**A1 IN NORTHUMBERLAND: MORPETH TO ELLINGHAM DEVELOPMENT
CONSENT ORDER (DCO): DEADLINE 4 SUBMISSIONS AND EXA WRITTEN
QUESTIONS.**

A1 IN Northumberland: Morpeth to Ellingham DCO Application Planning Inspectorate Reference: TR010059

Summary of Written Representations On behalf of the Environment Agency (EA)

**Key**

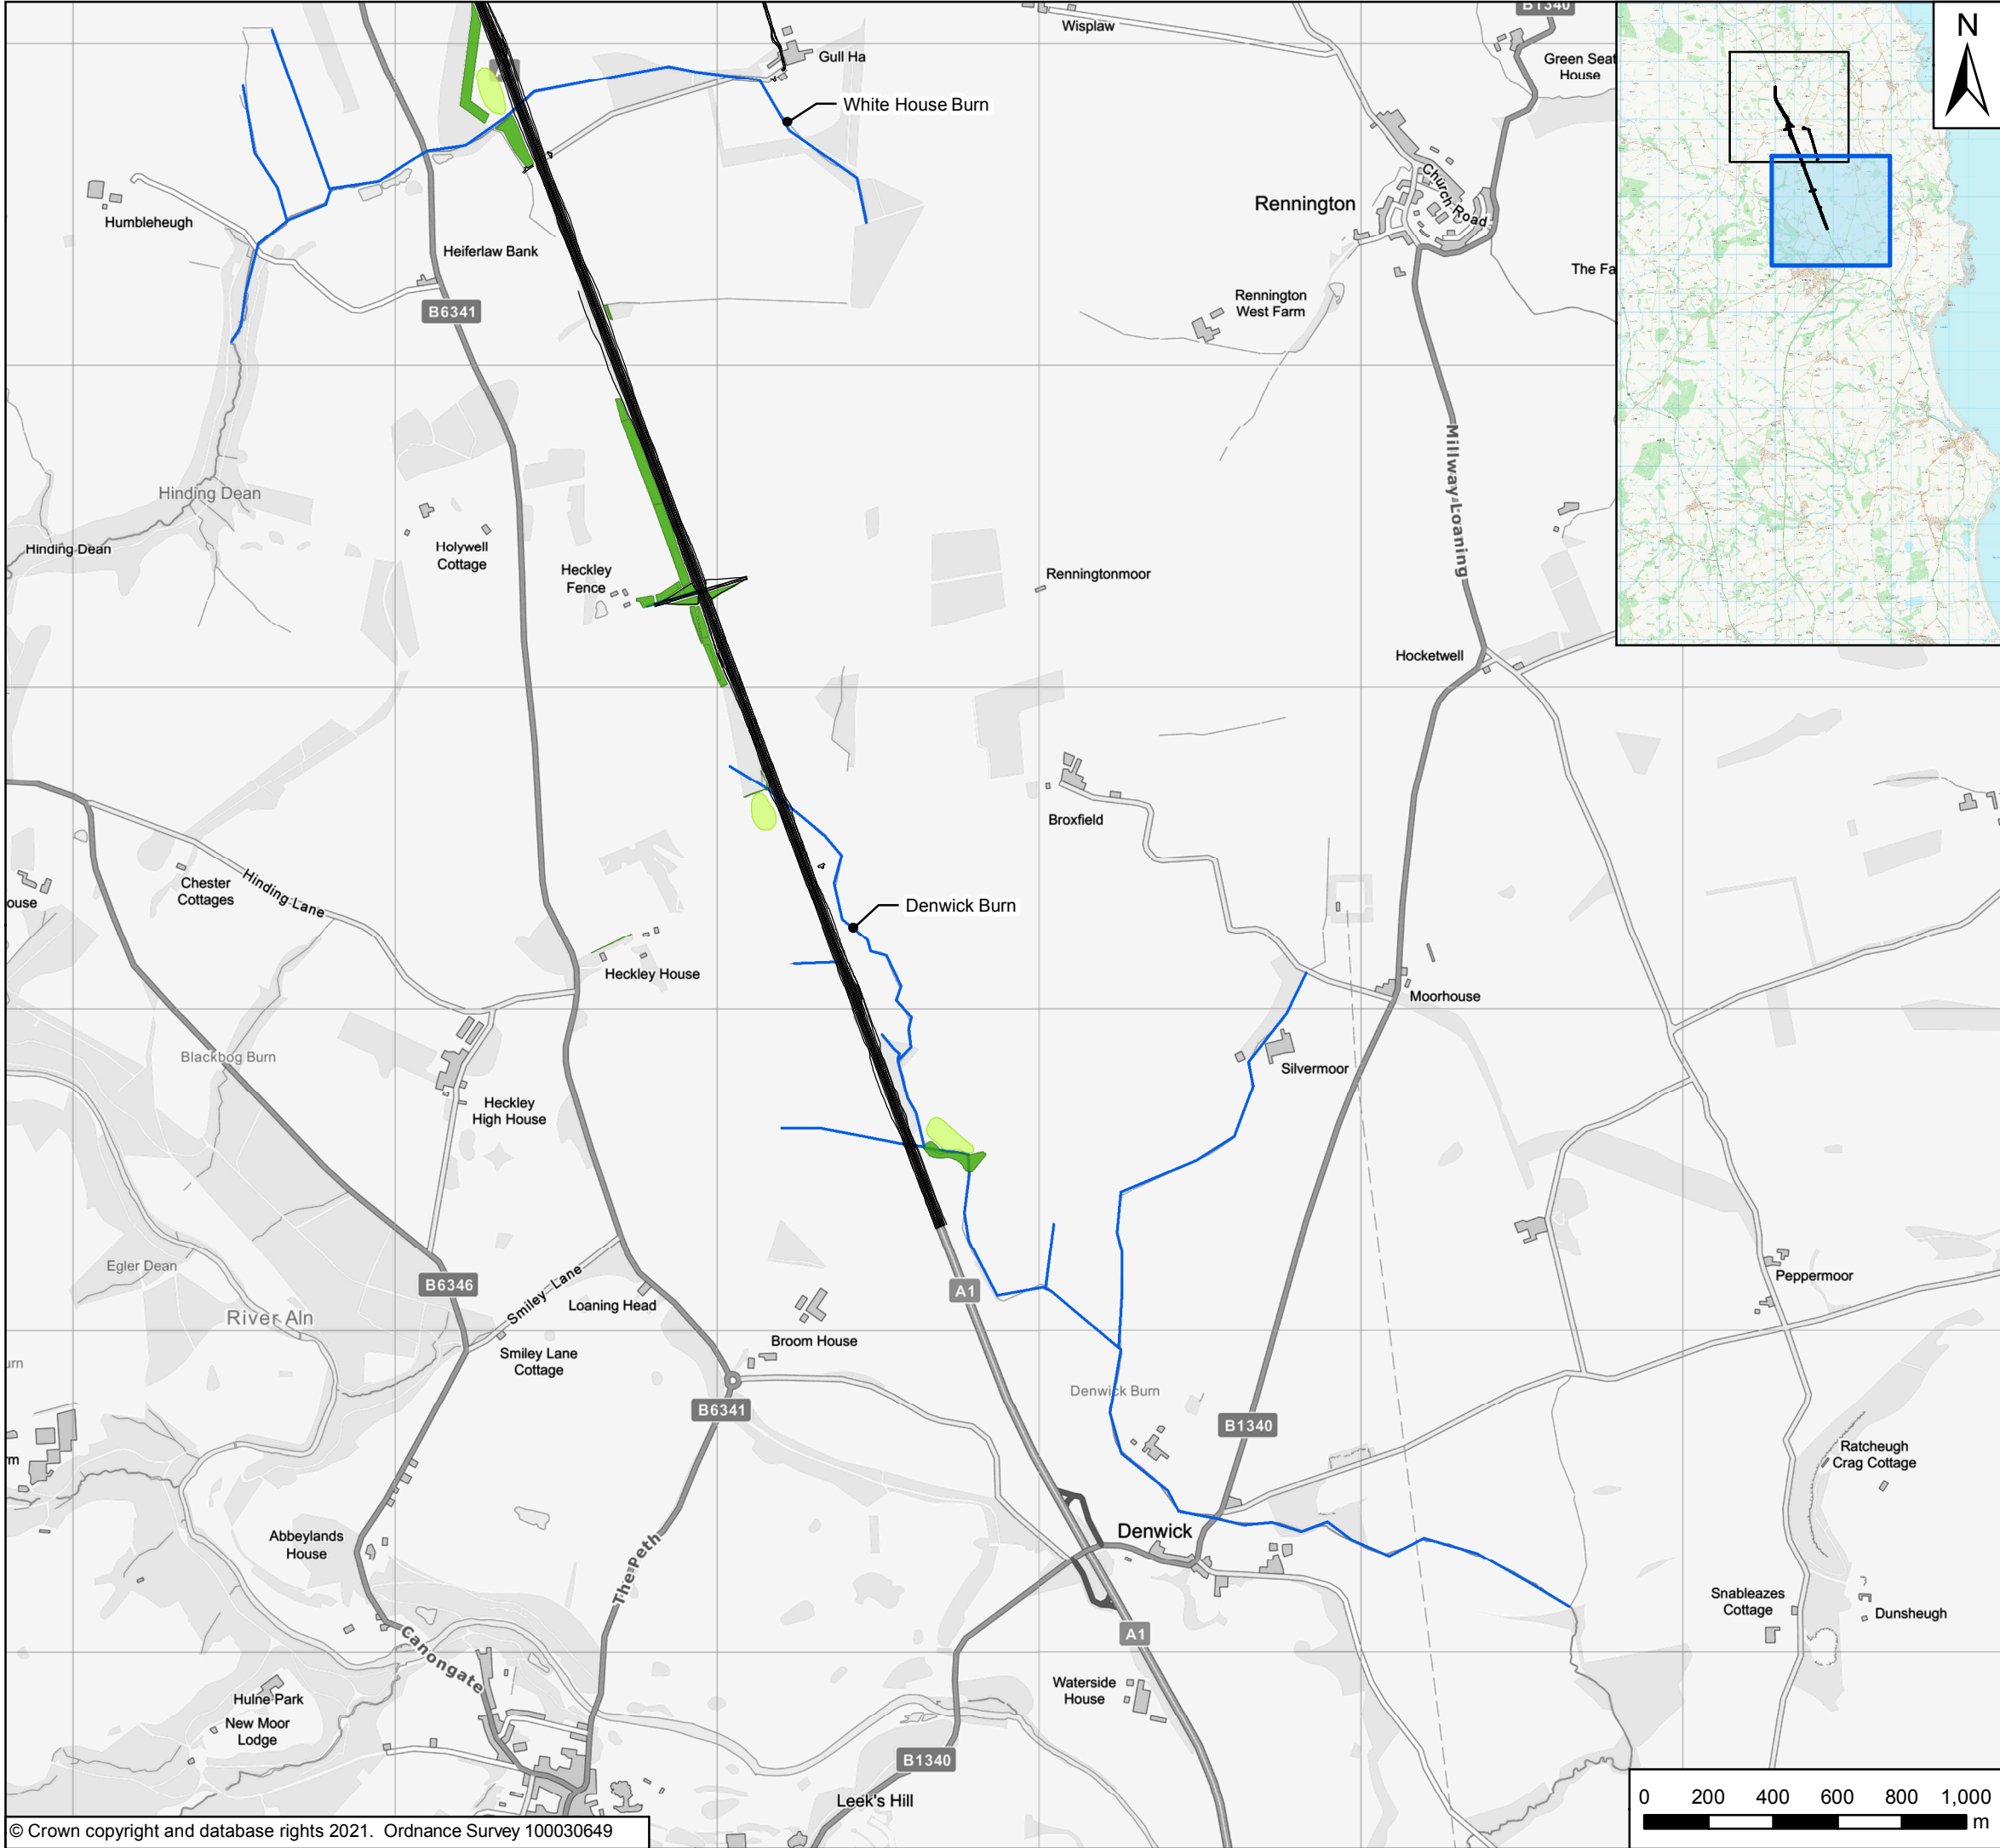
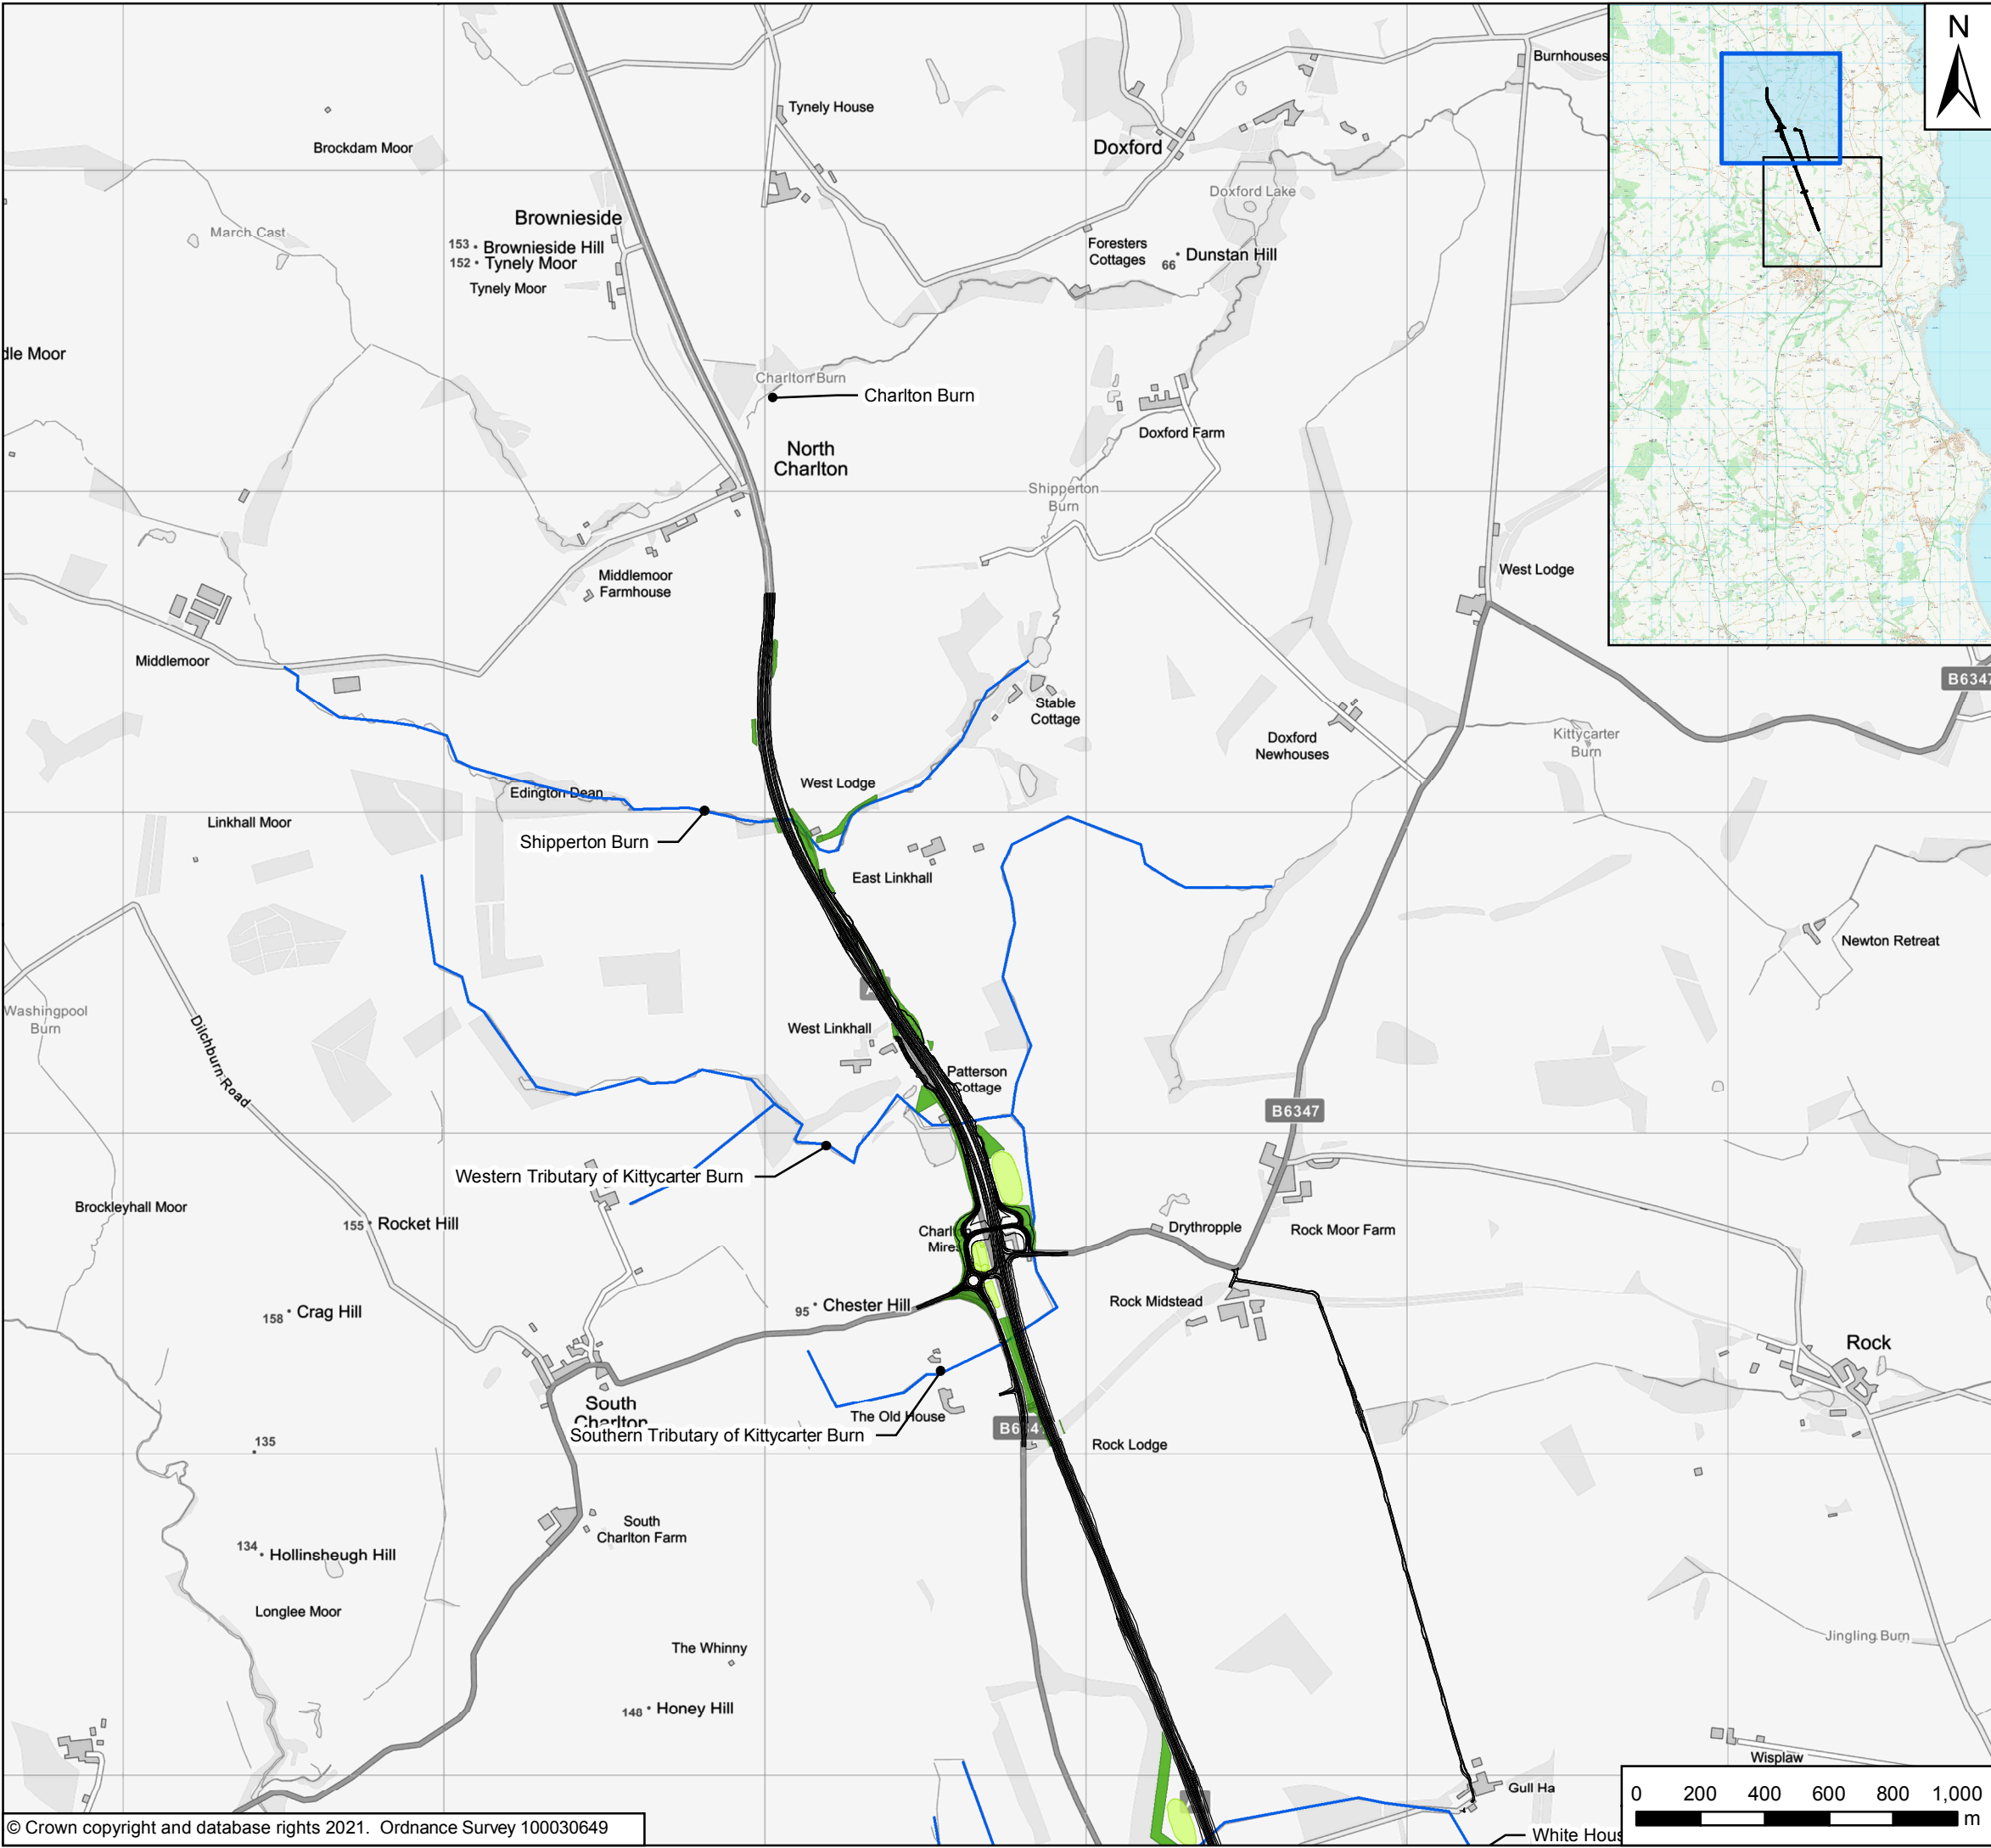
Deadline 4 Submission - 7.17.6 Written Summaries of the Applicant's Oral Submissions to Hearings: Appendix F - Proposed Woodland and Marginal Planting Plan (Part A and B) [REP4-031]

This clearly shows the vast majority of the woodland being planted as mitigation and compensation for the impact on the watercourse is neither 'wet woodland' as originally claimed nor riparian and is in fact broadleaf woodland. This habitat is not a water dependant habitat, has a different form and function and does not improve the watercourses affected by the scheme as the vast majority of this planting is disconnected from the watercourses. Therefore, we do not believe the proposals put forward by the Applicant adequately mitigates or compensates for the disturbance and damage to, and the loss of watercourses associated with the scheme.
